From: Martyn White <Martyn.White@arun.gov.uk>
Sent: 11 May 2021 16:23
To: Amy Myer <Amy.Myer@arun.gov.uk>
Subject: AL/35/21/DOC

AL/35/21/DOC

Norton Farm House Norton Lane Norton PO20 3NH

Approval of details reserved by condition imposed on AL/34/20/PL relating to condition 5-site plan showing details of hard landscaping

DRAWING TITLE
EXTERNAL WORKS

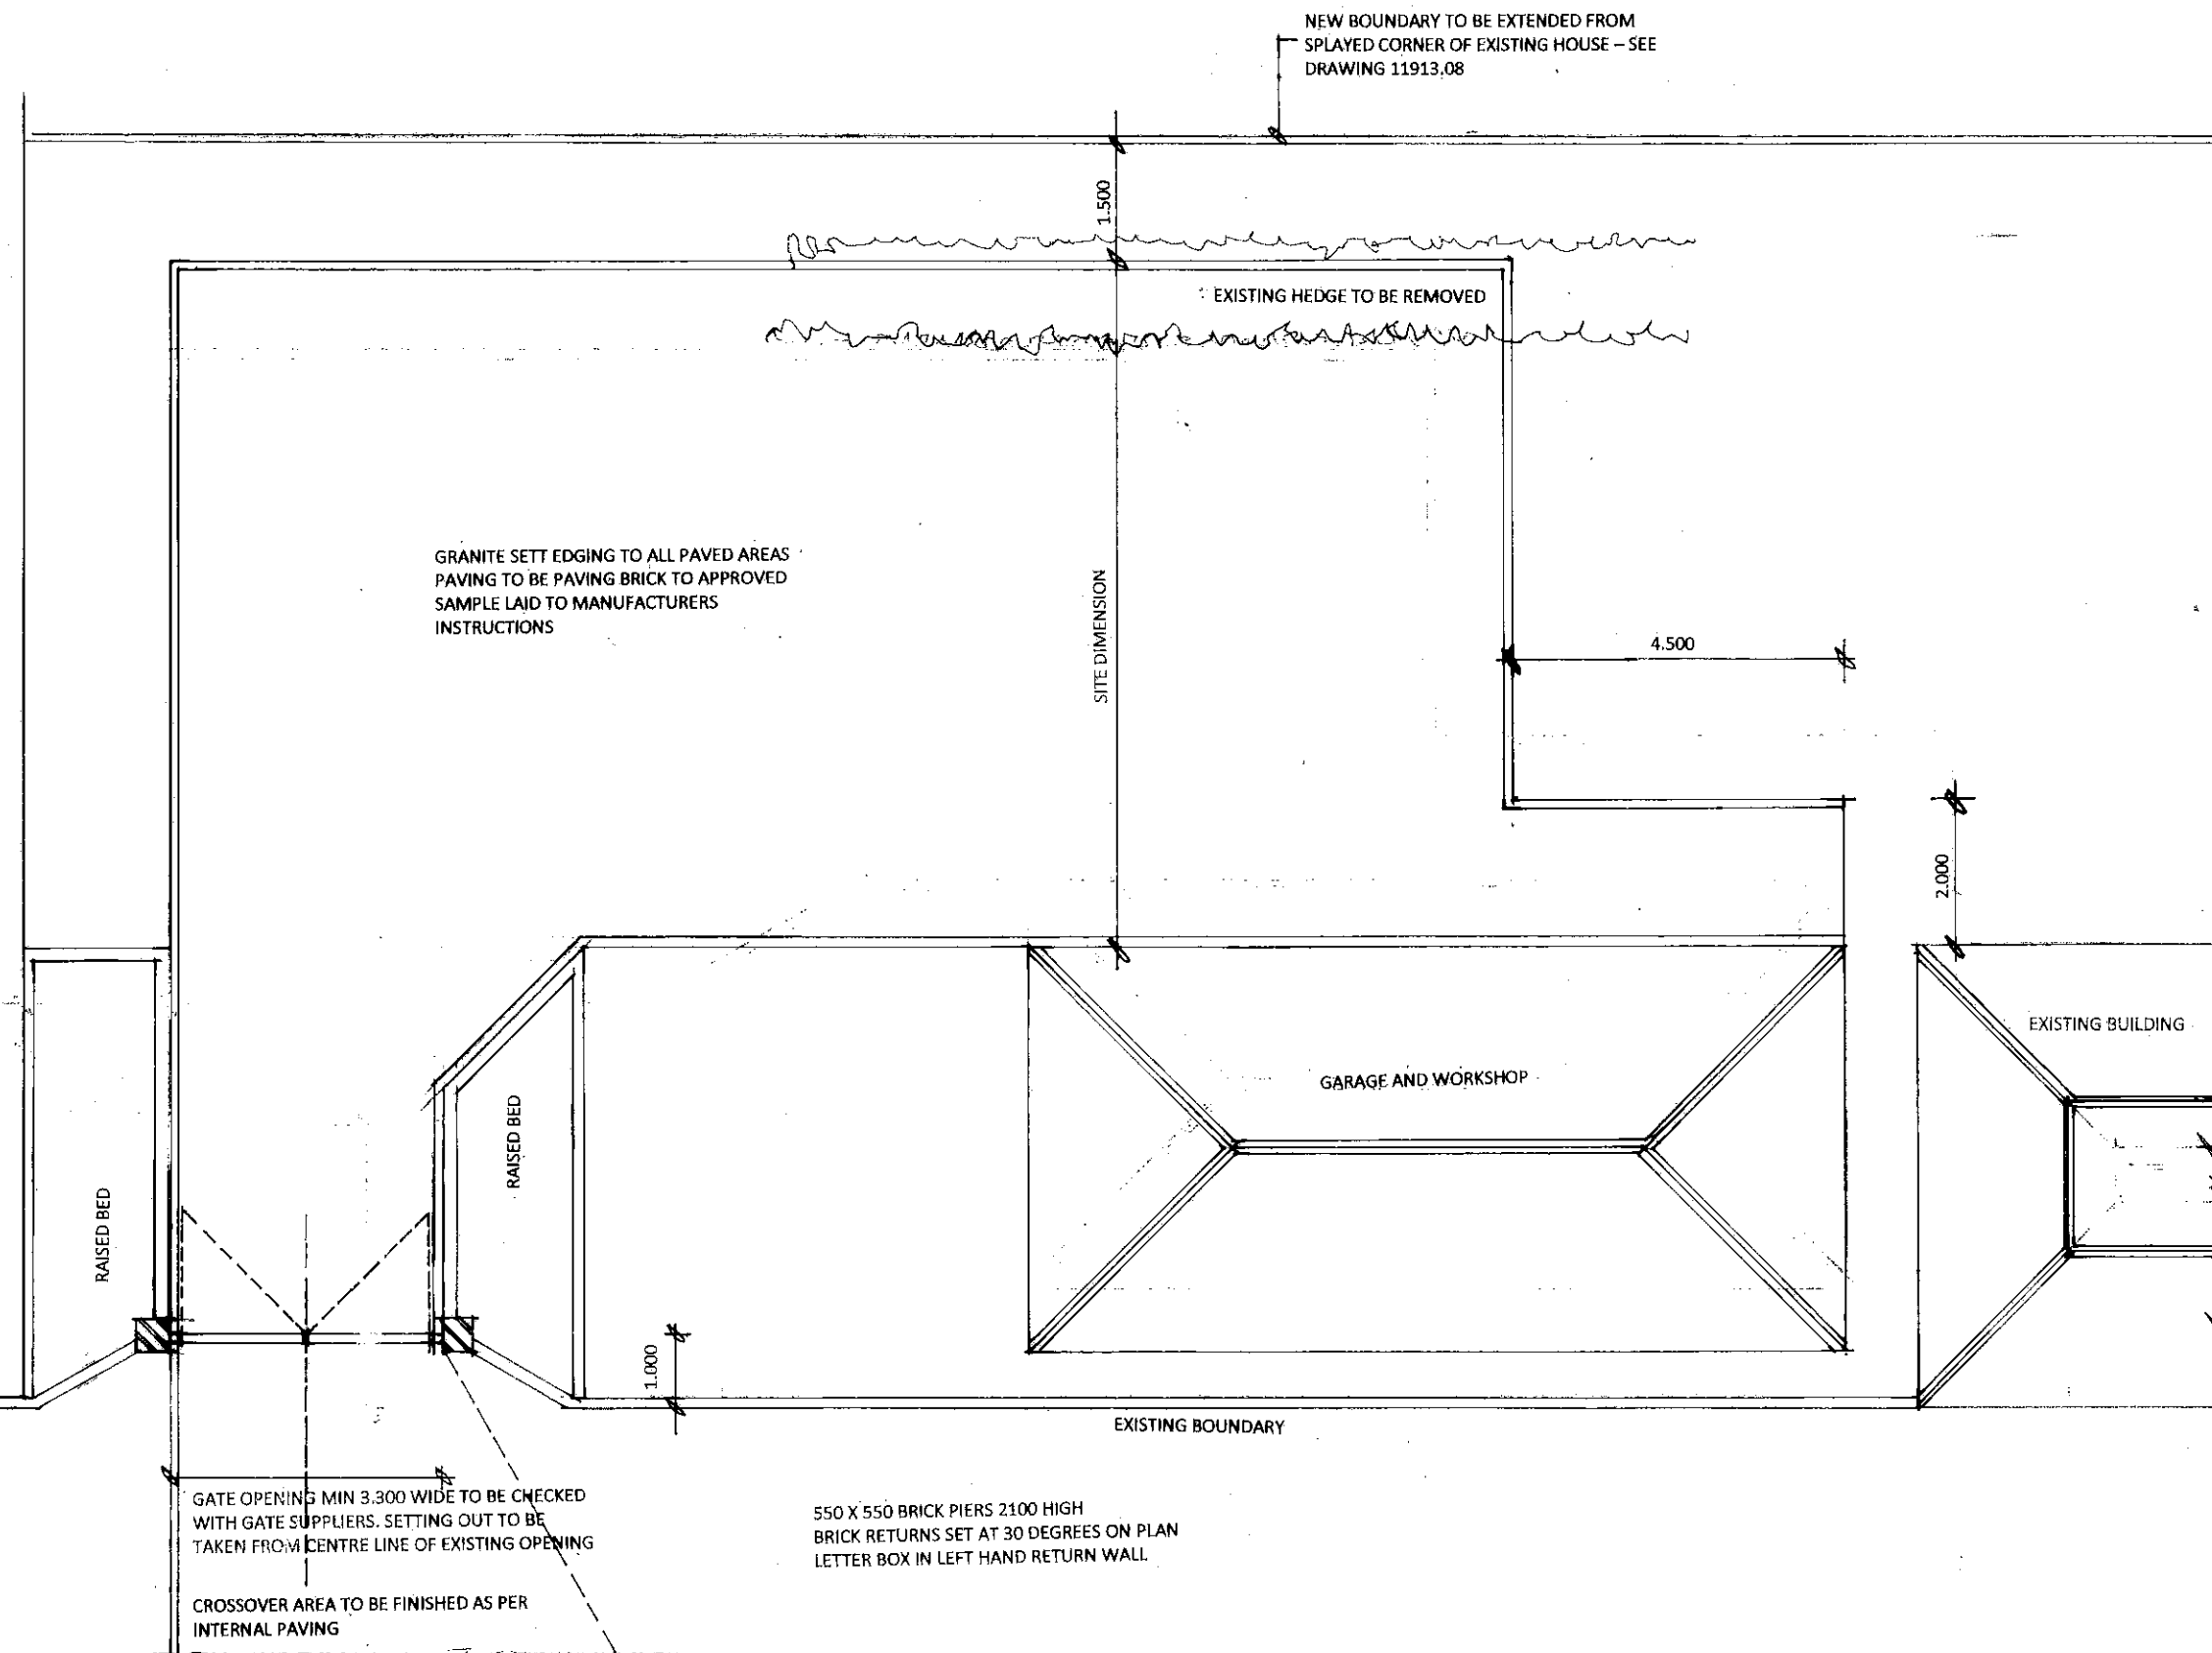
Having had the opportunity to review the plan, I would state that it is unfortunate that such a large area of the site is to be covered with hardstanding, with only two areas of planting (located close to the newly built brick gate piers). This is more of a sub-urban appearance as opposed to a more rural one. It is also not clear why such a large area is required, especially when the majority of it is not located to the front of the new building. The proposed brick paving is also a fairly standard material in what appears to be a dark colour.

association with the new development, and I note from the plan that the intention is to screen the area from the main listed building through the use of a 'boundary treatment'. This would be positive, but requires the use of appropriate materials and design (which is not provided at this time).

However, in the absence of any information regarding the proposed boundary treatment, it is considered that the large area of paving would be visible from the conservation area, and in the context of the listed building and could be harmful.

The plans provided as part of this application indicate that other works are also proposed as part of the development, including gate piers (which are under construction). I believe that these would also require permission. This would require a full assessment in order to understand the impact.
